COLORADO GEOLOGICAL SURVEY

November 28, 2017

Subject: Springs East at Waterview, Preliminary Plan (SP-17-010)
El Paso County, CO; CGS Unique No. EP-18-0011

WATERVIEW EAST
PRE-DEVELOPMENT GRADING AND EROSION CONTROL PLAN

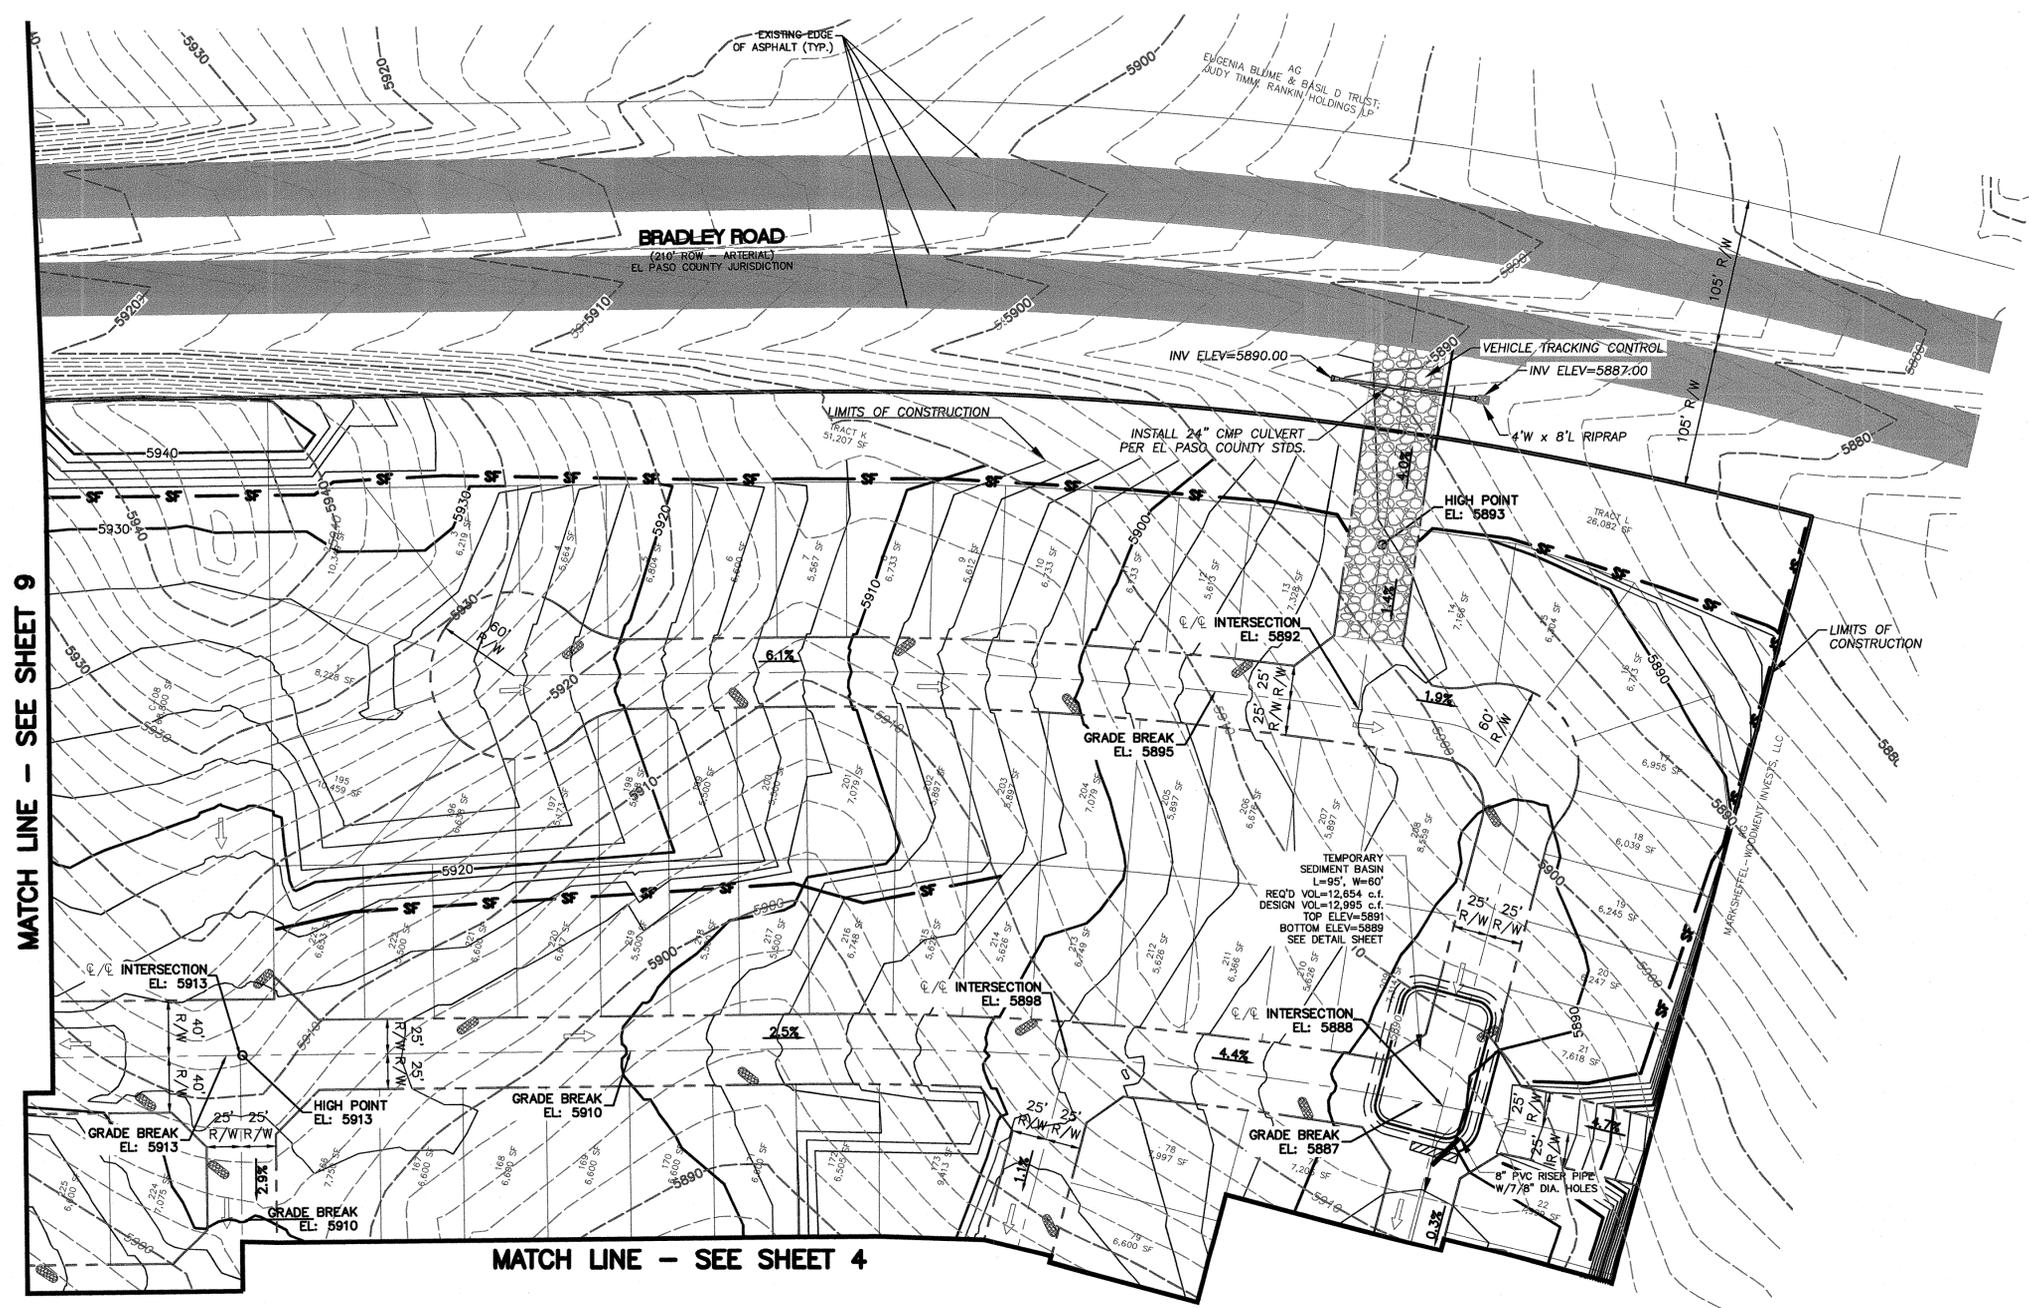
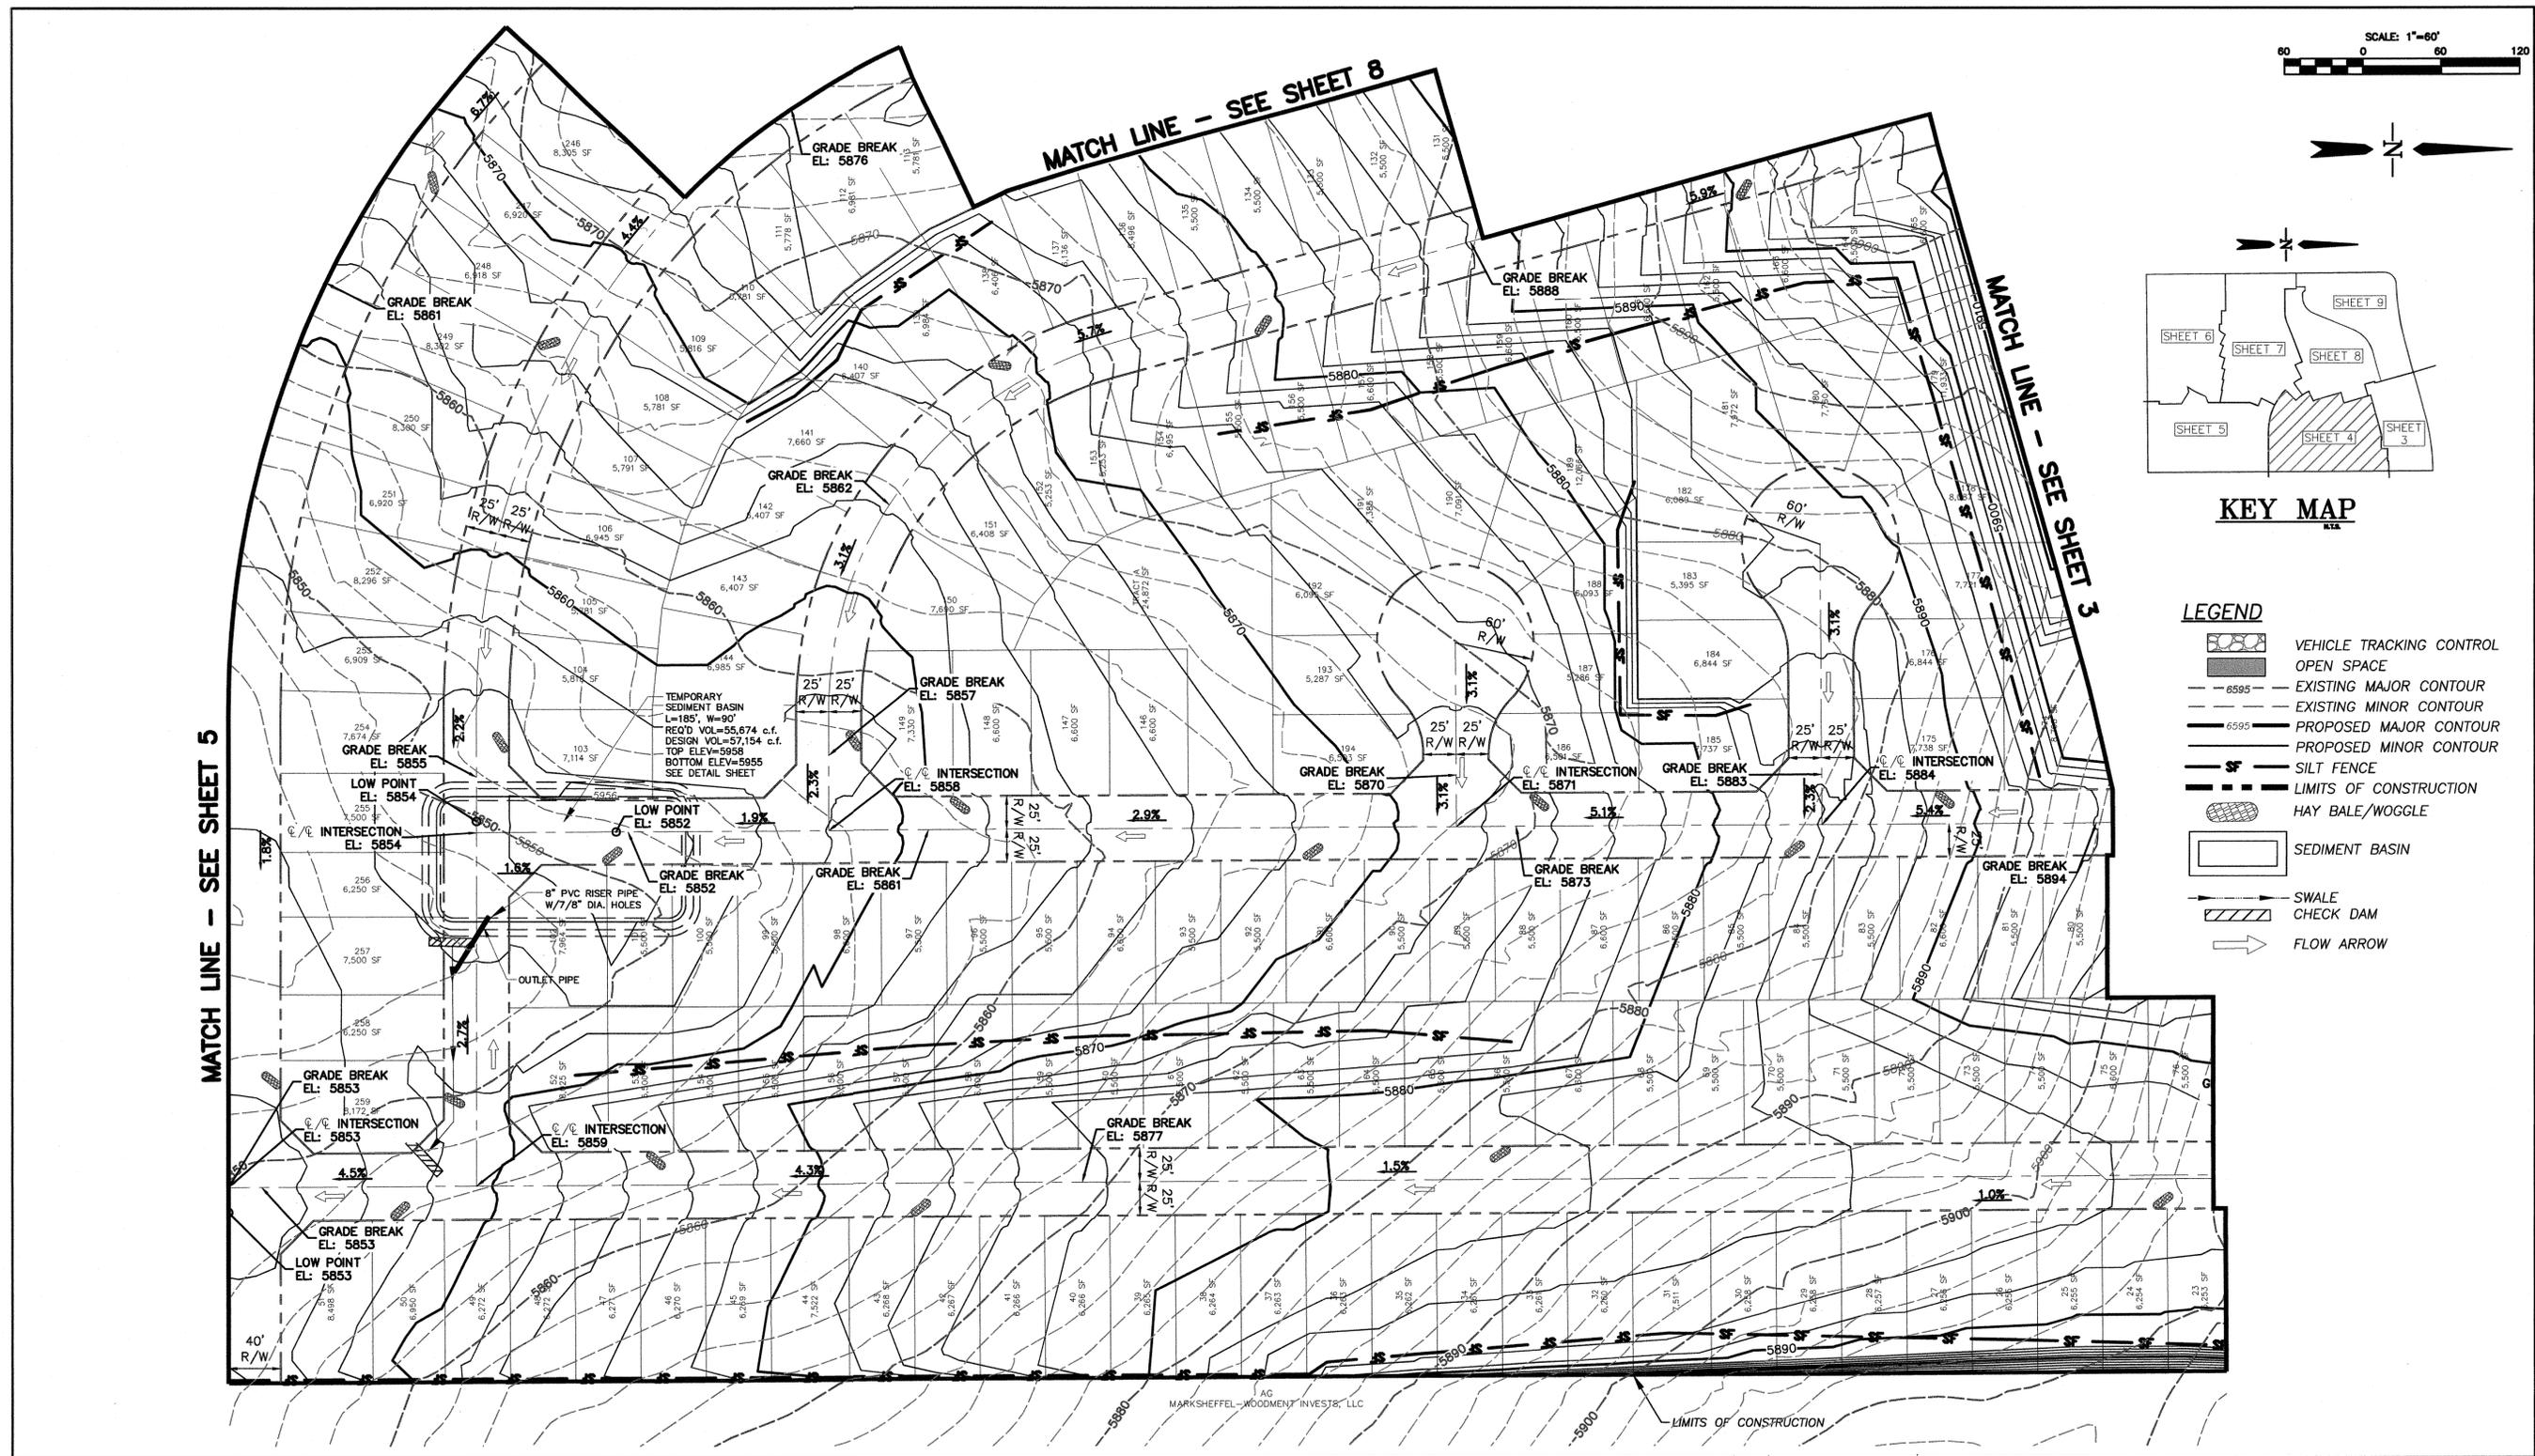
Entech's ten borings were drilled to a depth of 20 feet. The Waterview East Grading and Erosion Control Plan (Stantec, April 3, 2017) indicates that significant cuts and fills are planned, with cuts exceeding 20 feet in some areas. Some of Entech's borings, including but not necessarily limited to TB-1 in the northeastern area of the site, therefore may not extend to sufficient depths to provide meaningful information about soil and bedrock engineering properties and groundwater levels. Additional investigation, sampling, testing and analysis are needed, based on the project grading plans, to characterize subsurface conditions, determine depth and extent of overexcavation, if overexcavation is planned to reduce the use of drilled pier foundations, and to determine basement feasibility in areas of significant cuts where Entech's borings did not extend to sufficient depth below planned basement floor and foundation bearing depths.
